From: Amanda Scholes on behalf of Planning.Responses
Sent: 17 July 2017 08:46
To: Planning Scanning
Subject: FW: Development in sea drive Ferring

JOB: 1 SEA DRIVE, FERRING, WORTHING BN12 5HD
DWG: PROPOSED SITE PLAN

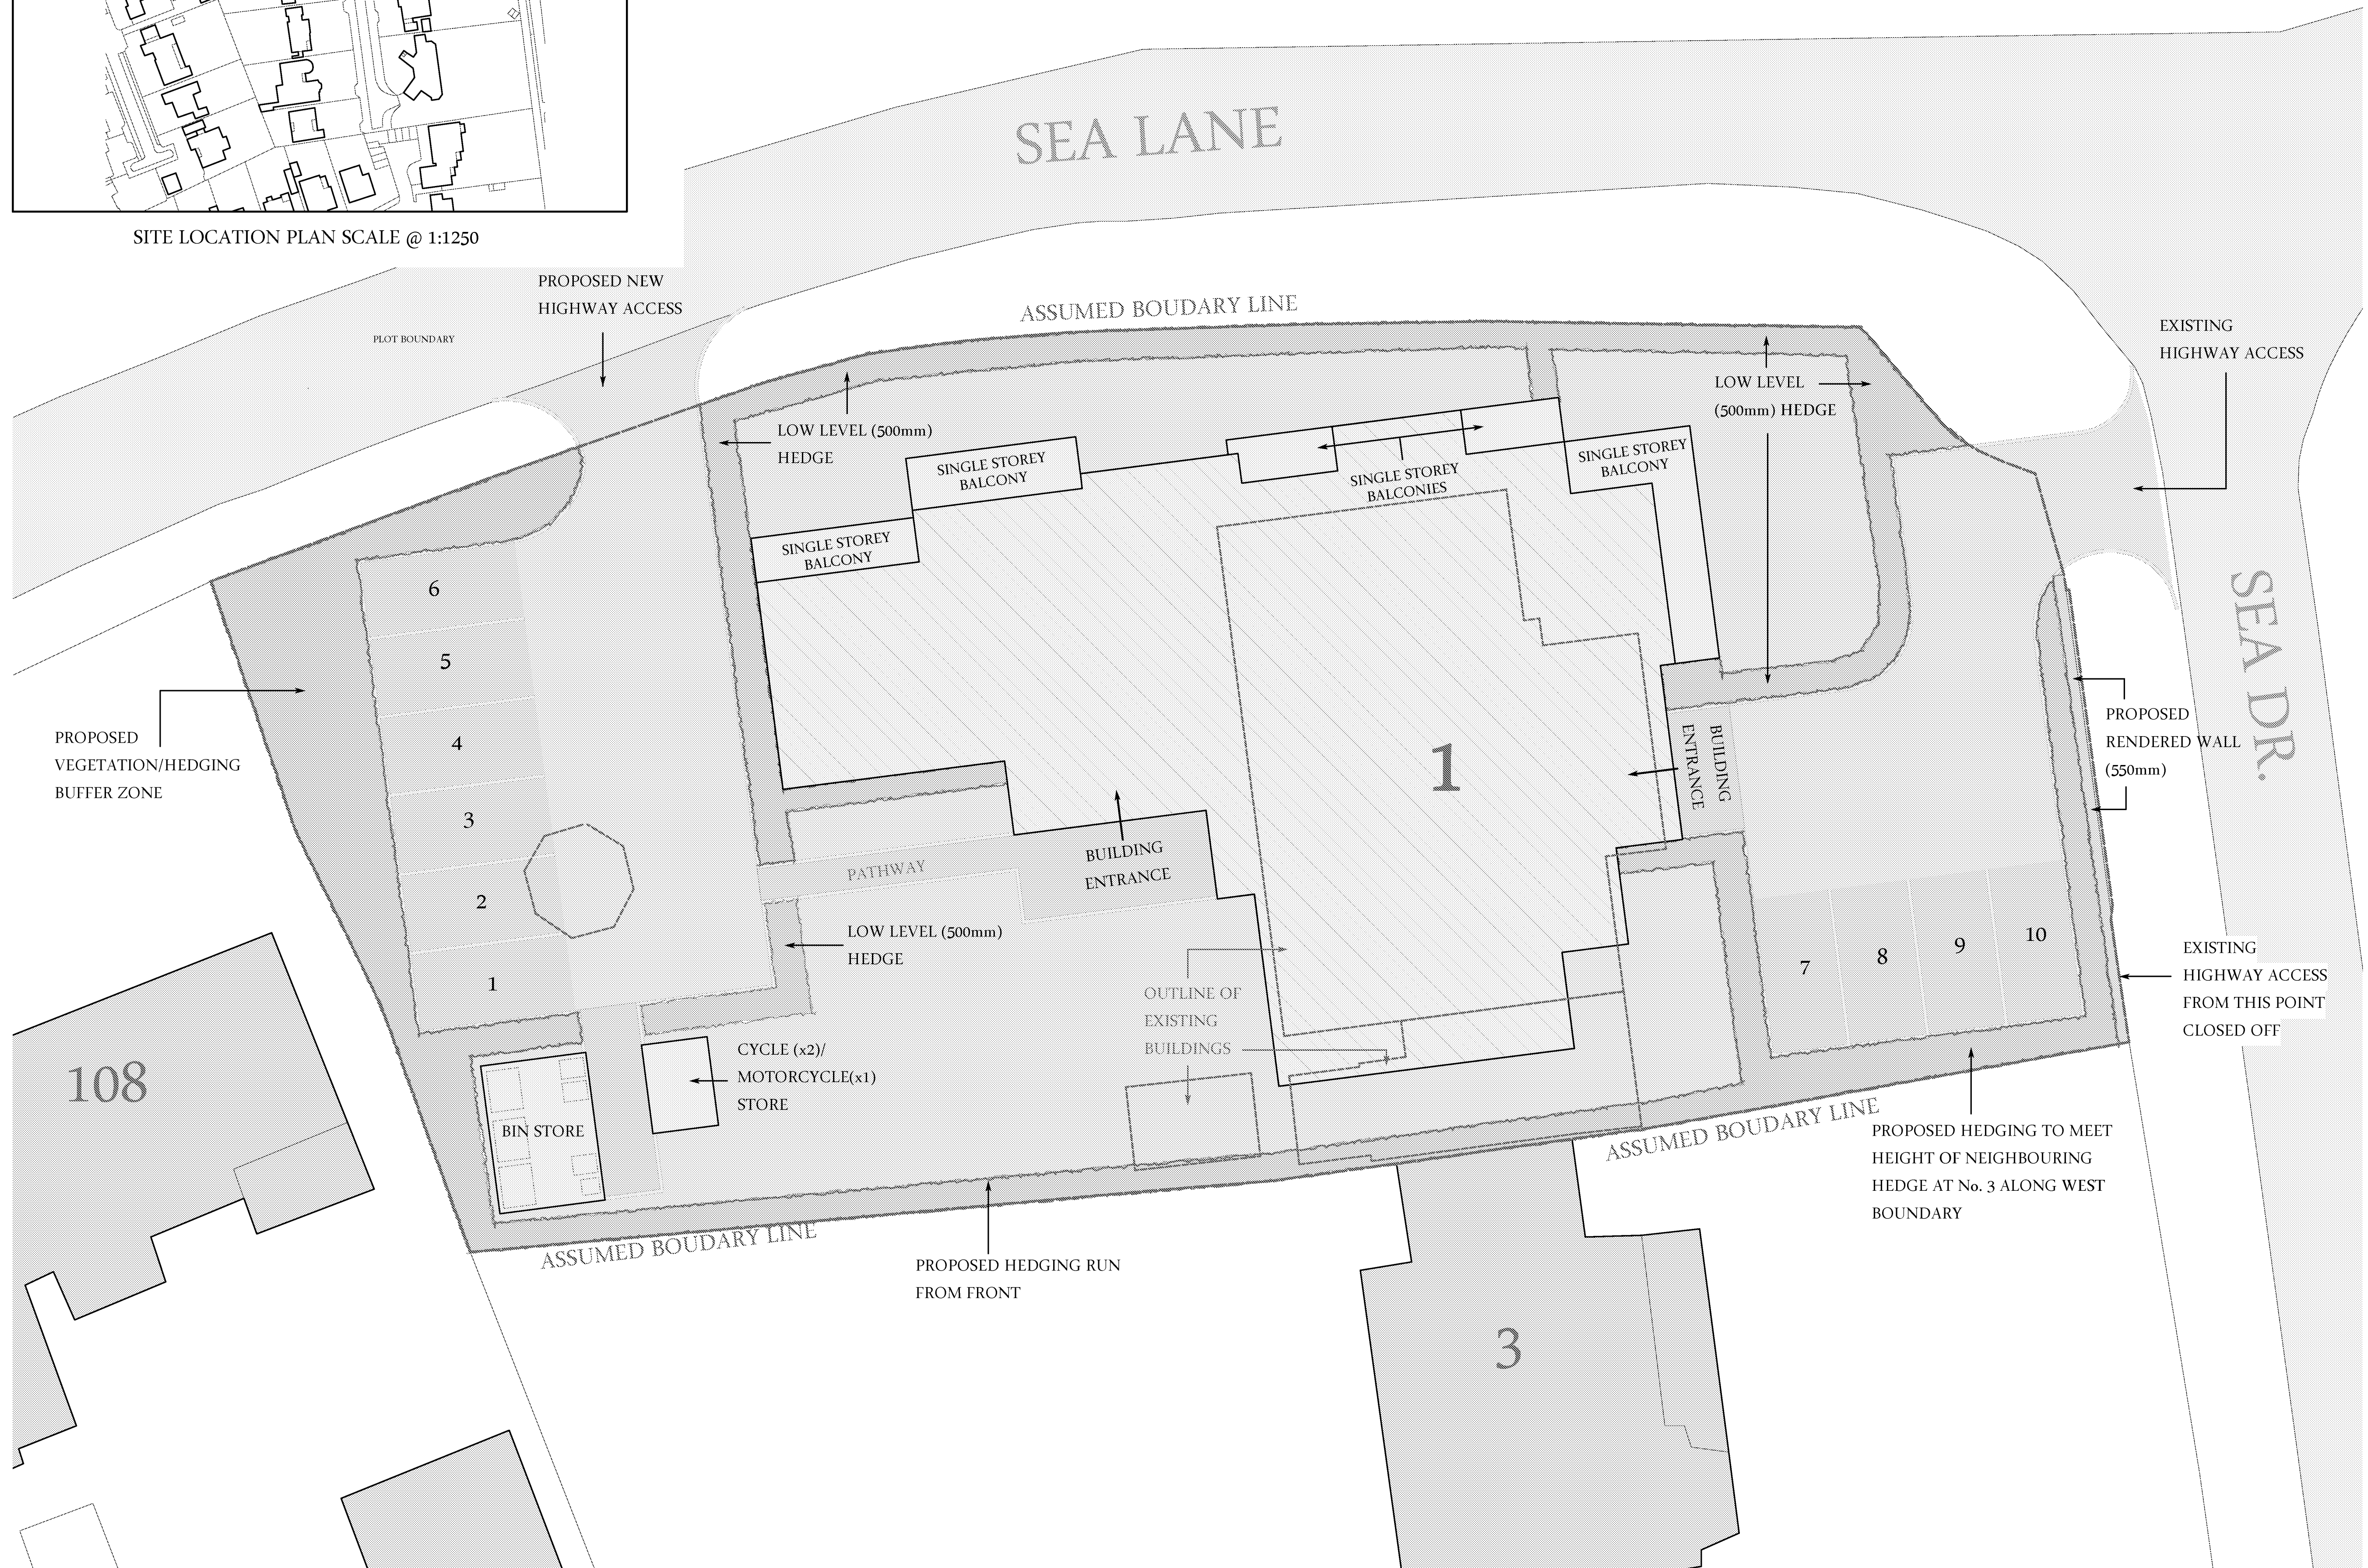
From the tracking of the underground carpark previously it was tight

But now they have spaces tight to the east wall that take away the useable turn gap they had previously.

As we all know there is not enough room for cars to pass on the ramp to the underground carpark, there also no allowance for delivery vehicles that block sea drive regularly and this will only get worse.
